Recommendation Report for Planning Permission

REF NO: LU/266/21/PL

LOCATION: 215 Timberleys
Littlehampton
BN17 6QD

PROPOSAL: Erection of 1 No. 4 bed dwelling (resubmission of LU/350/20/PL). This application is in CIL Zone 4 and is CIL Liable as new dwelling.

Title
**PROPOSED ELEVATIONS
NO 215A TIMBERLEYS
TIMBERLEYS**

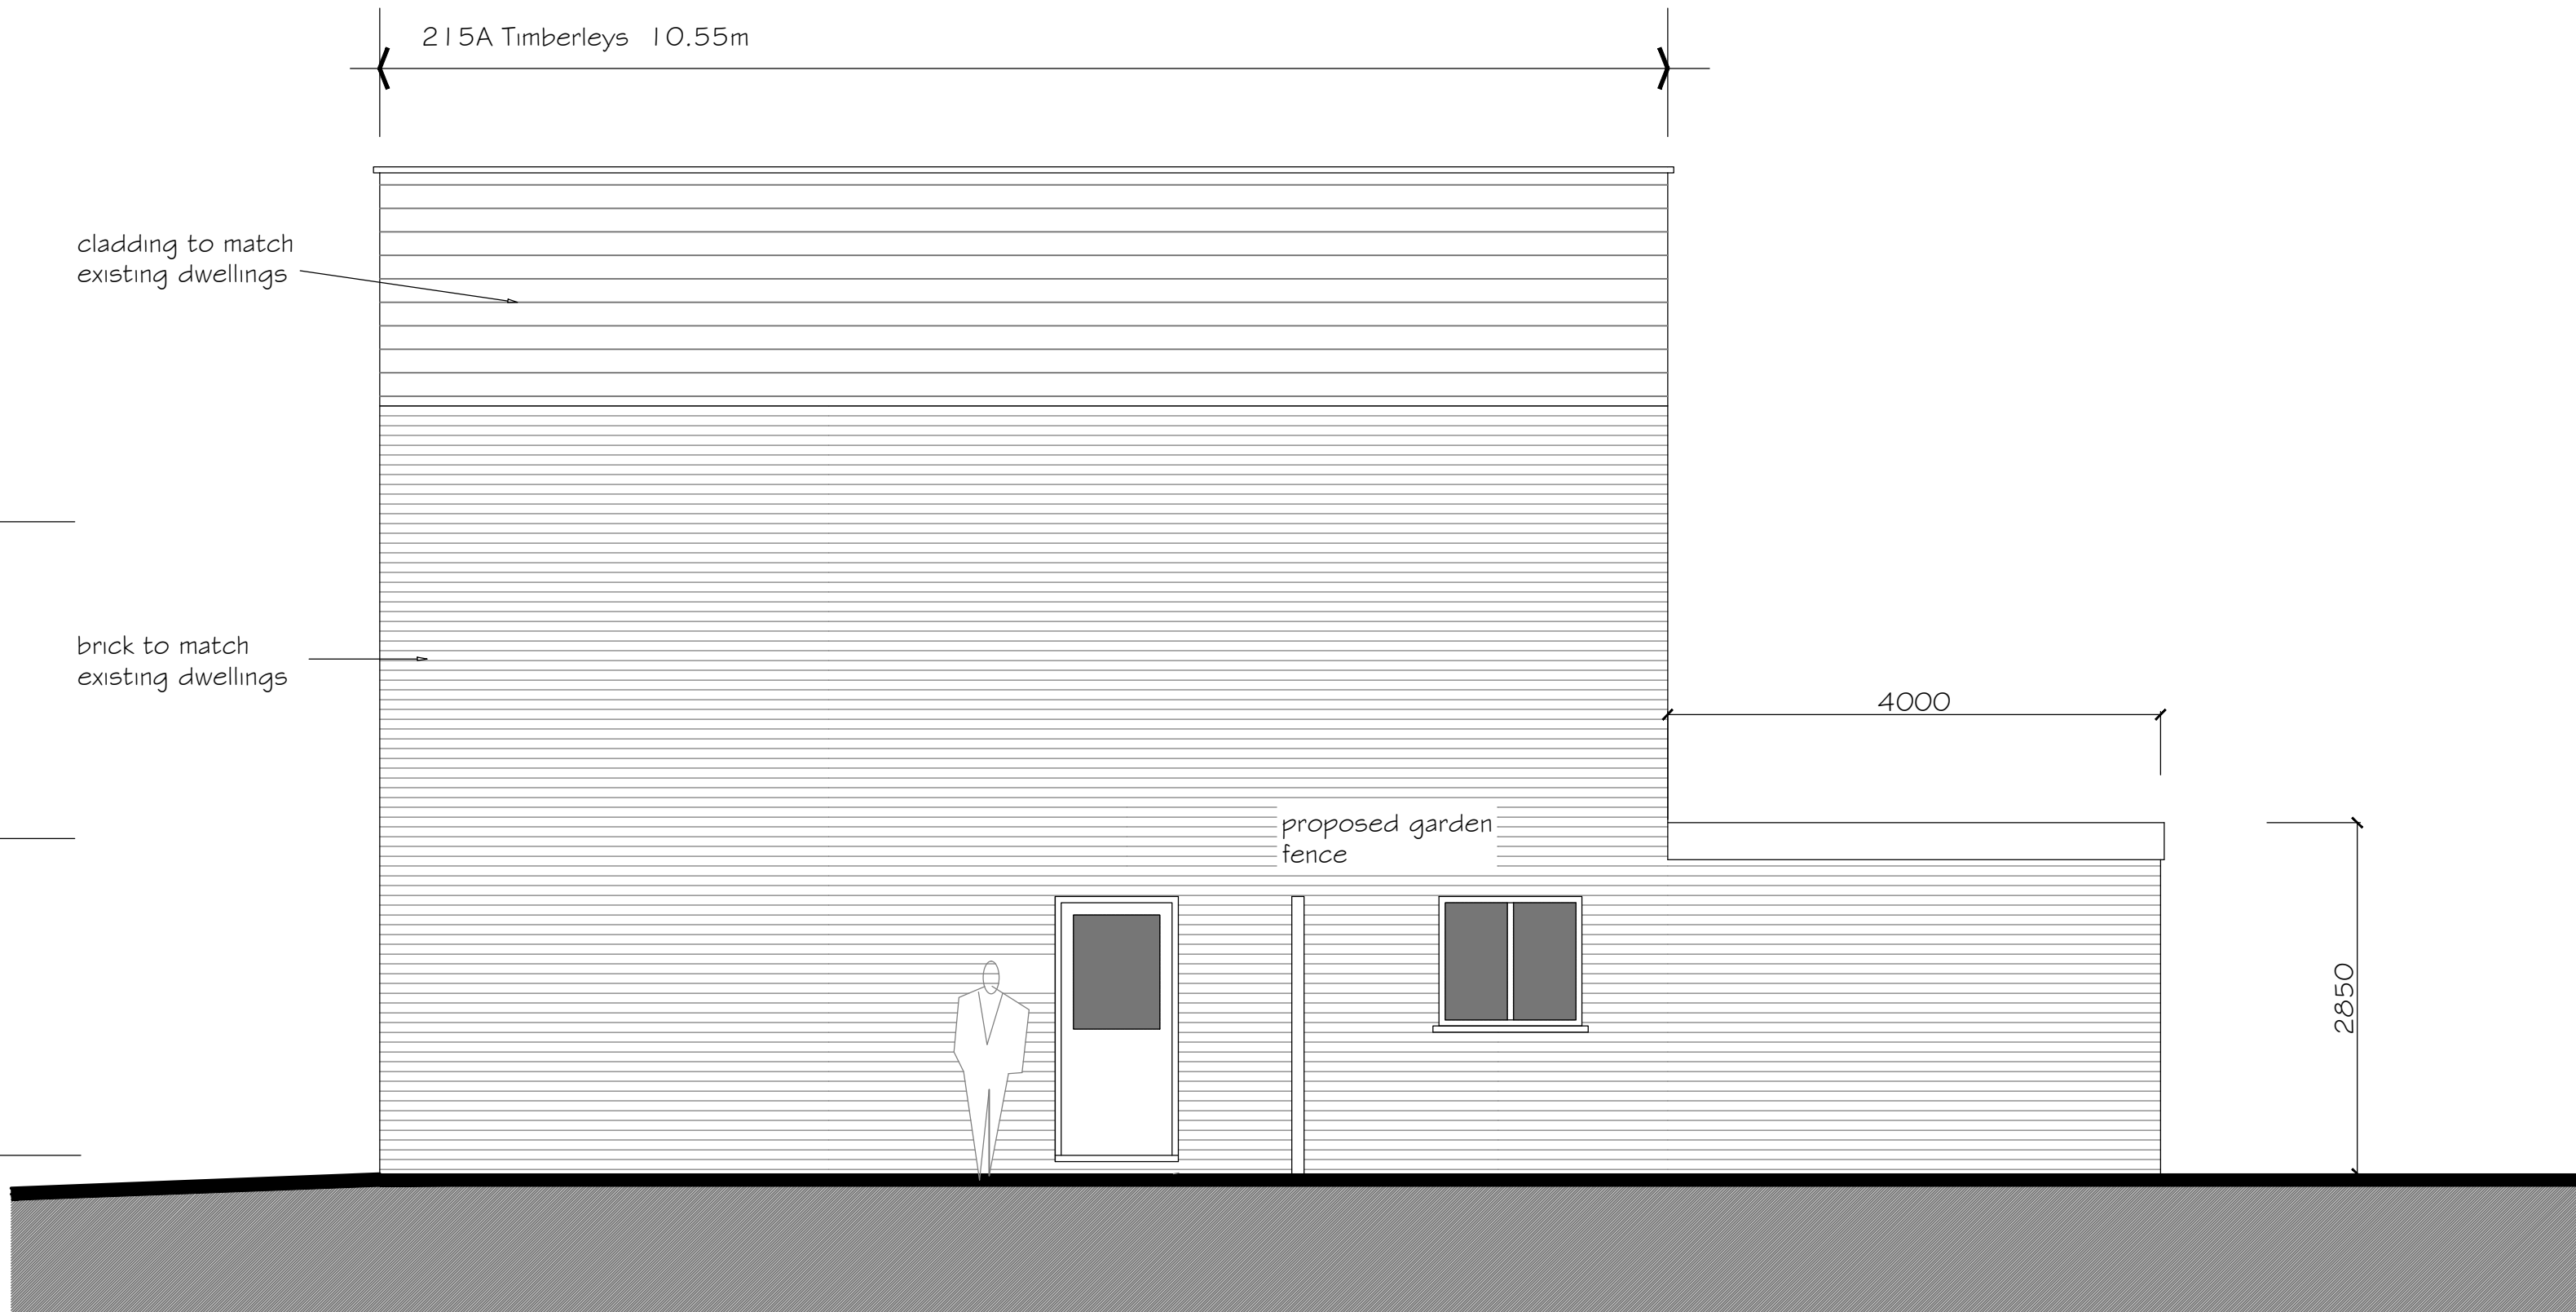
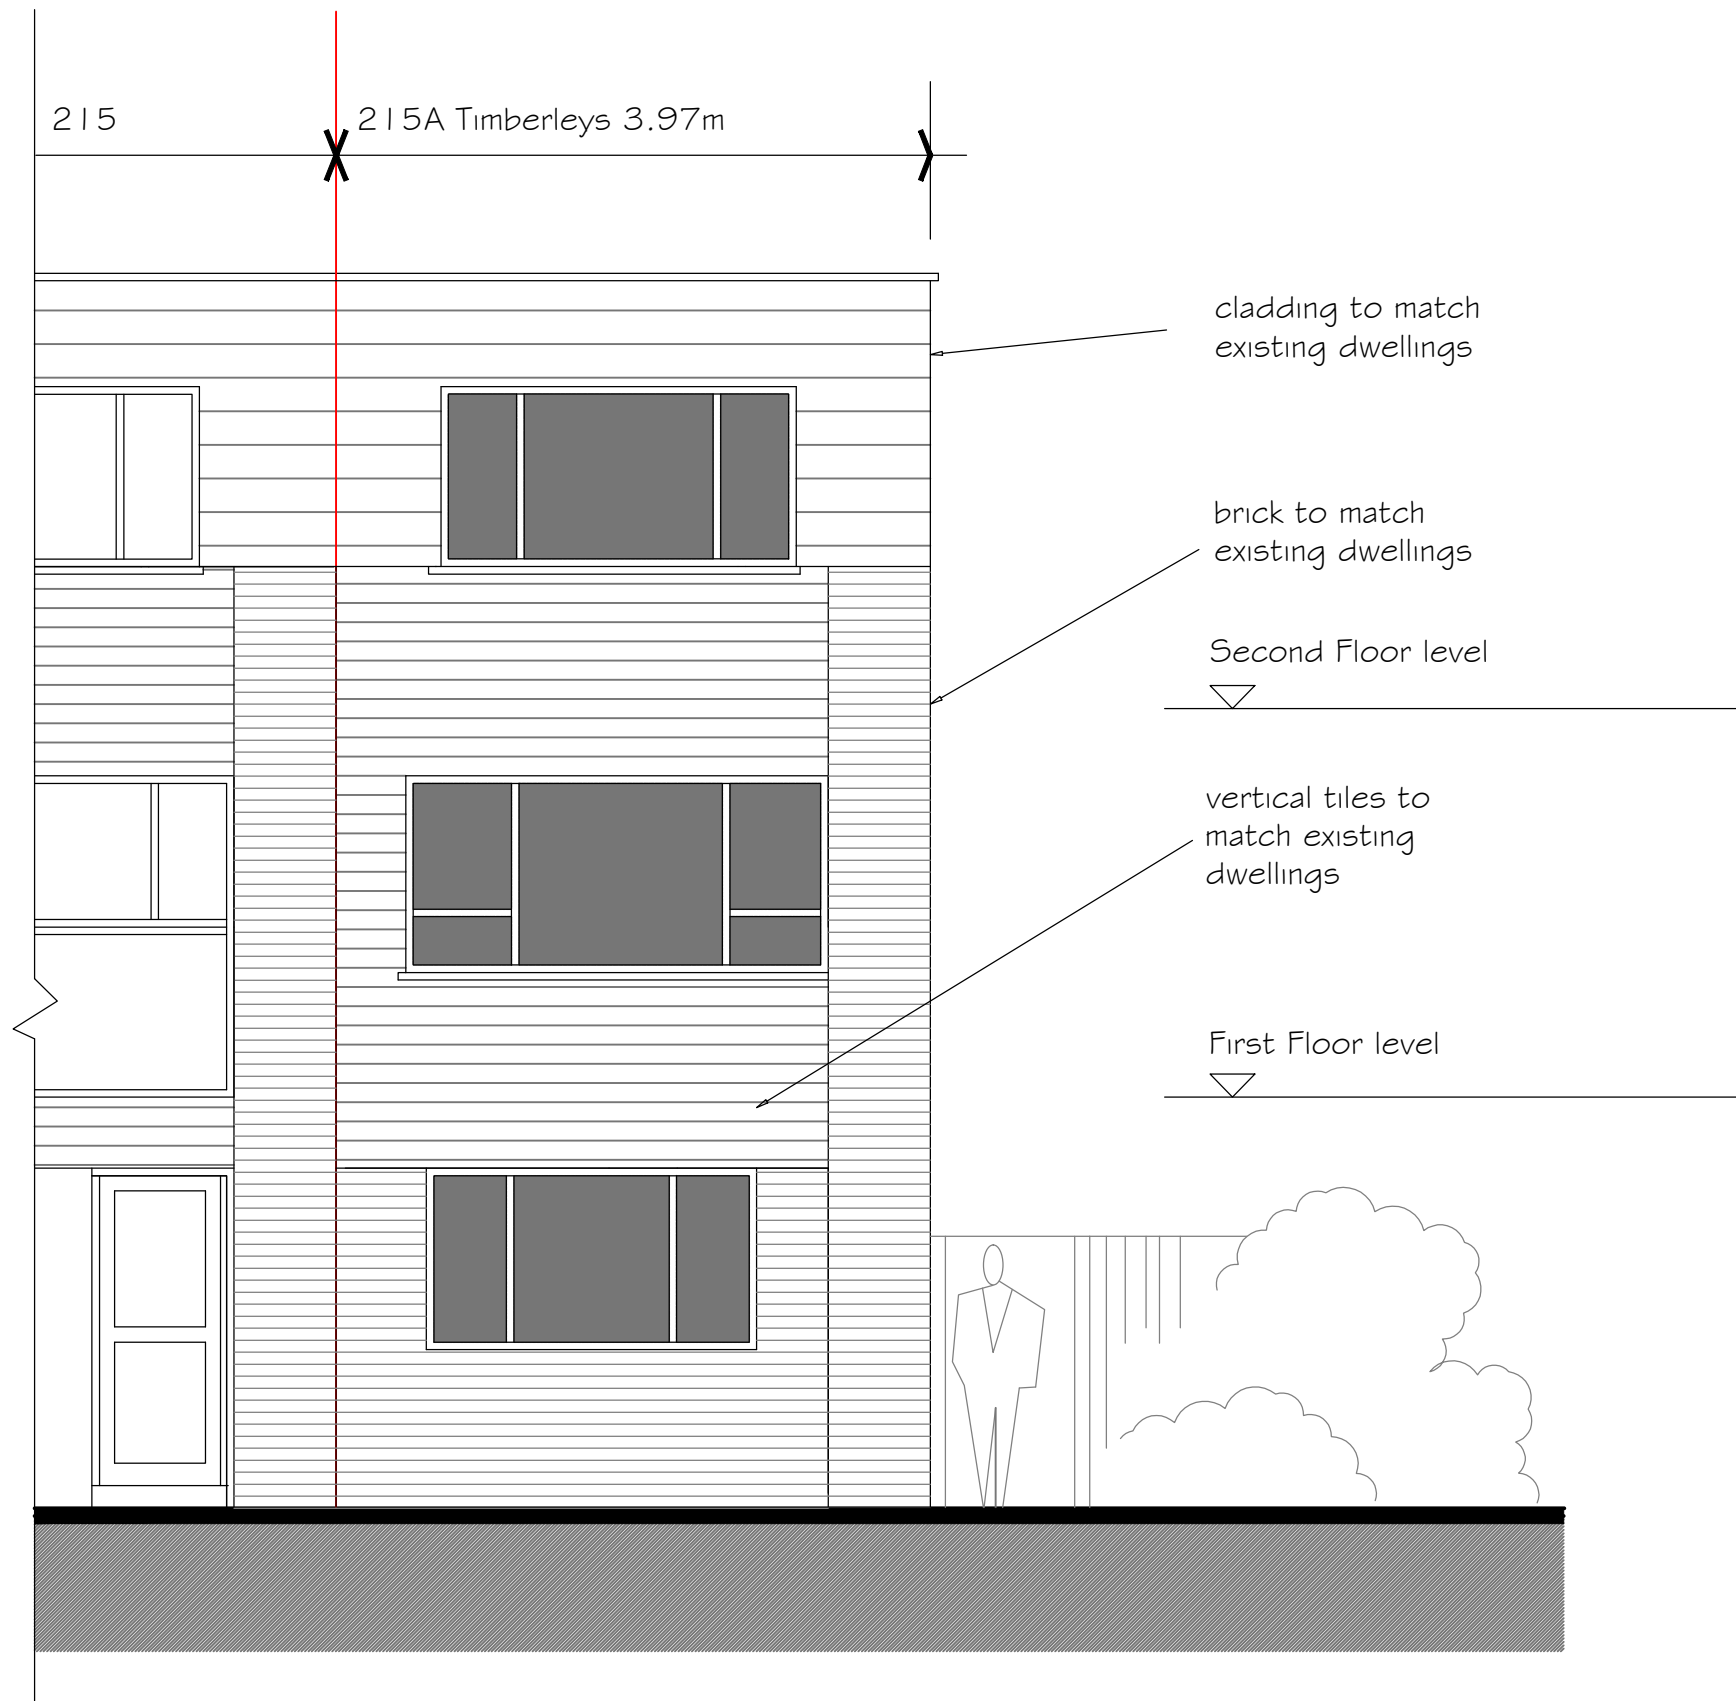
The Northern boundary of the proposed dwelling would face towards Worthing Road. At its closest point, the proposed dwelling is approximately 1m from the Northern boundary of the application site, then widening to 5m. Whilst this is close to the street scene of this highway, it is not considered that the proposal would give rise to any unduly dominant appearance within this street scene, this is due to the separation distance provided by the planting and the foliage present between the site boundary and this public footpath ie this mitigates any potentially harmful impact.

The proposed development would not project forward of No. 215 Timberleys, nor others in the terrace. However, the rear protrusion of the proposed dwelling does infringe on the 45-degree rule for rear extensions and conflicts with Part P of the Arun Design Guide. It is believed that this protrusion (extension), which will be built up to the party wall line shared with No 215, will be overbearing on the future occupiers of this space and create an unsatisfactory relationship between both dwellings. As stated within the application documents, when the property is built it will be afforded Permitted Development Rights and the applicants could provide an extension to the rear of the property of up to 3m in depth. However, this does not automatically include the right to build a Larger Homes Extension under a Prior Notification, which an extension of this size would require. To be allowed such an extension the due process of a Prior Notification Application should be undertaken, rather than gaining the extension by default as part of this application.
